Pinsent Masons

**A12 CHELMSFORD TO A120 WIDENING SCHEME – TR010060
POST-HEARINGS SUBMISSION – ROYAL LONDON UK REAL ESTATE FUND AND
EDMUNDSON ELECTRICAL LIMITED
9 MARCH 2023**

**Plate 2: EEL in Relation to DCO Route and Sheepcotes (Illustrative)**

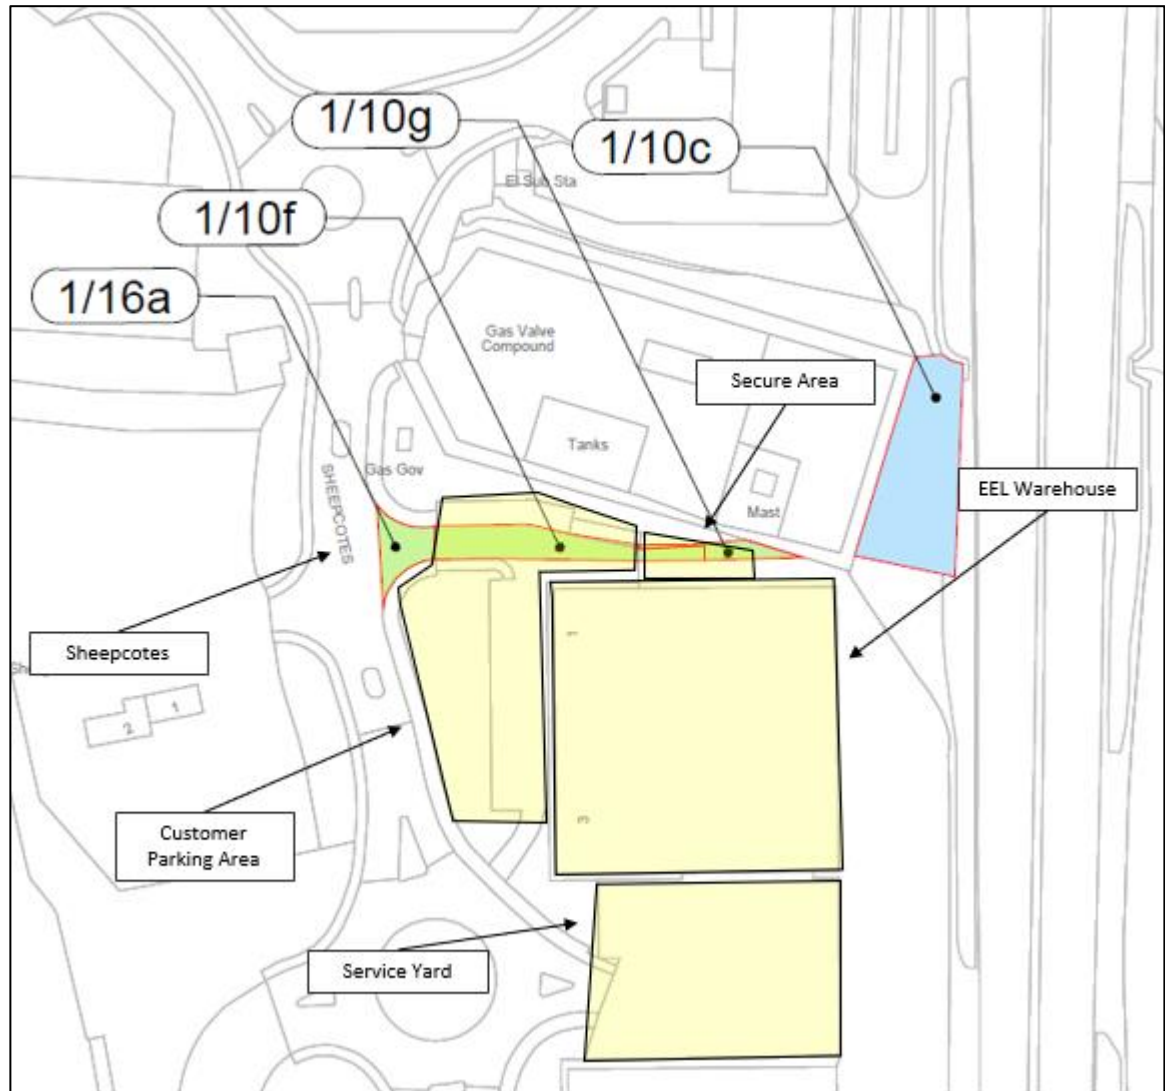
- 2.3. Access through the EEL site is sought by the Applicant for the purpose of carrying out gas diversion works (Work No.U2 of the dDCO [**AS-020**]). Reference is made to the plan at plate 2 on page 6 of the document appended to the Royal London and EEL written representations [**REP2-100** and **REP2-099**] to provide a visual illustration of what is proposed.

- 2.6. Royal London and EEL consider that there is no evidence or information covering whether:
 - a. additional vehicles are required for the overhead powerline works included in the Scheme proposals required as a result of the gas diversion works. There is no indication as to the number of vehicles required for these works or whether they are included in the proposed 20 vehicle movements required for the gas diversion works;

- b. the largest vehicles can pass safely along the proposed access;
 - c. the width of the access (plot number 1/16a) is sufficient for the vehicles required;

- d. vehicles will have sufficient space to turn around safely and pass back along the access;
 - e. the largest vehicles could pass each other on the access or that the works can be undertaken with 20 vehicles on the site and any deliveries required for those works.

**Plate 7: Proposed Gas Works Diversion (Extracted from Utility Diversions August 2022)**

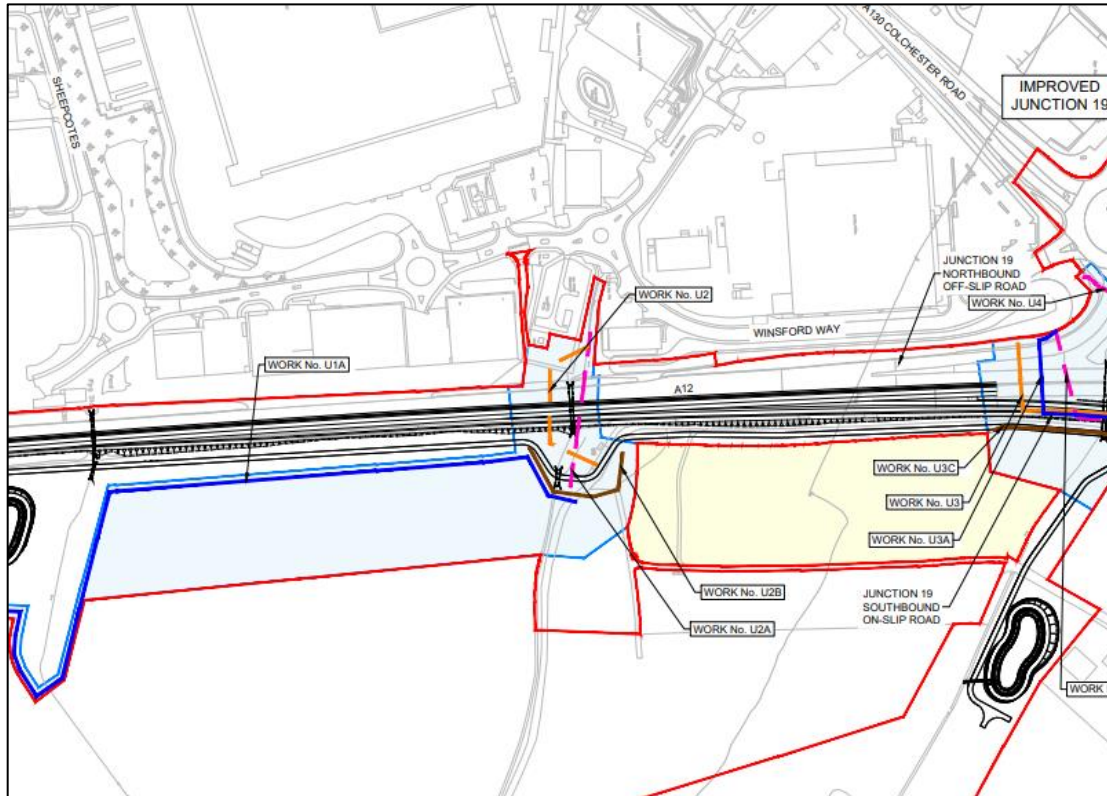
- 4.5. The current route and proposed route of Work No.U2 is shown on sheet 1 of the Utility Diversions plans [AS-003]. Royal London and EEL have not seen any report or optioneering carried out to determine that the proposed new route for the pipe is the optimum route. In addition, Royal London and EEL have been told this is not the final detailed design for the new route and Cadent's written rep [REP2-042], suggests the work to date is preliminary: "*The Diversions have not yet reached detailed design stage and so the final positioning, land rights and consents required for these gas diversions are not confirmed by Cadent.*"

- 4.6. Royal London and EEL have queried why the new pipe could not go straight across and link up to the existing pipework to the north of the current proposals. That would negate any need for access through the EEL site. In addition, Royal London and EEL have raised a query as to why, even if the new pipe route remains as currently proposed, access could not be obtained from the north through Cadent's own site, the Trilux site or direct off the A12 – see more details in the text for Issue Specific Hearing 1 above.

- 4.7. The Applicant has indicated that the access route cannot cross either the stream or the overhead cables. The proposed new pipe route crosses both the stream and the overhead cables. A route straight across would not. It appears that the proposed new pipe route requires the overhead lines to be diverted as part of the Scheme (Work No.U2A) – more information on the timing and location of this is needed from the Applicant. If the gas diversion route should in fact be re-directed e.g. further north under the carriageway, it may be that the access off Sheepcotes is unsuitable and rights over Royal London's land at plot number 1/10c (and therefore the access) or through the EEL site (plots 1/10f and 1/10g) are not required.
